**Staffordshire County Council**

**WMI Written Representation Summary**

TITLE:  
EXISTING LOCAL ACCESS  
RESTRICTIONS AROUND WMI

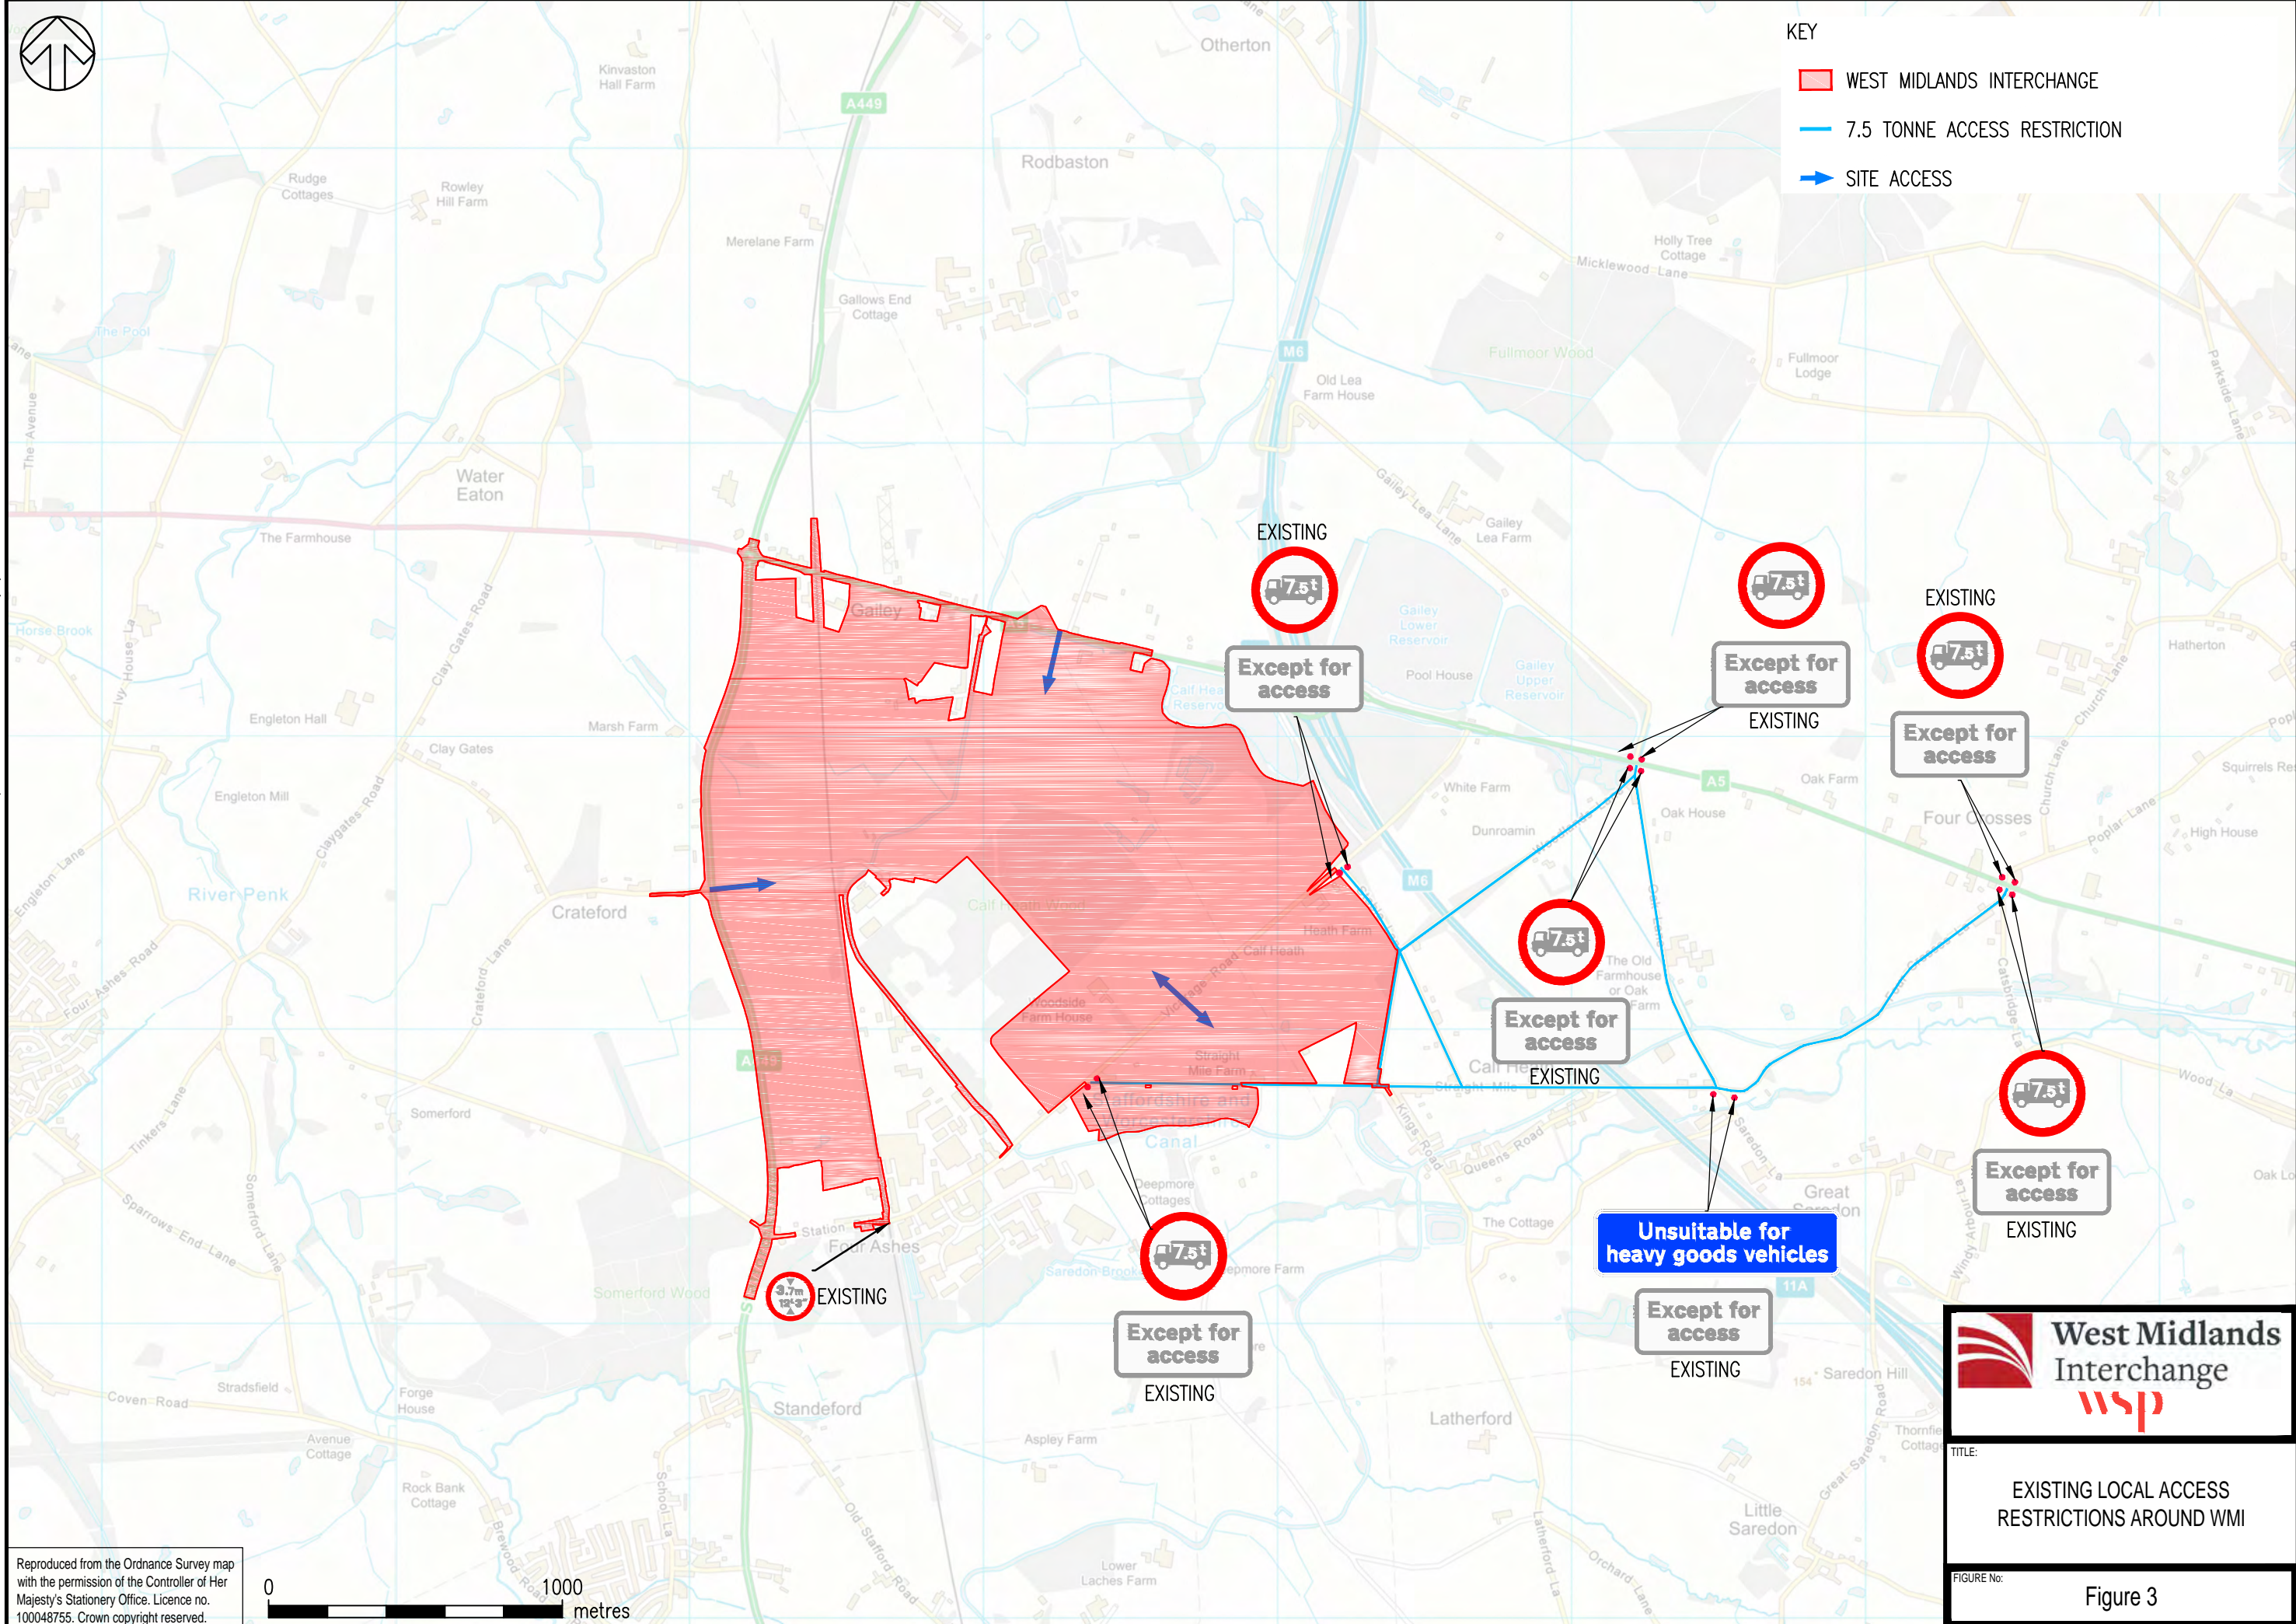
- 1.3. FAL are proposing a HGV ban on HGV movements on the A449 through Penkridge. It is critical that the HGV ban is secured robustly and is enforceable to prevent HGV journeys routing through Penkridge when the motorway is open but running slowly.
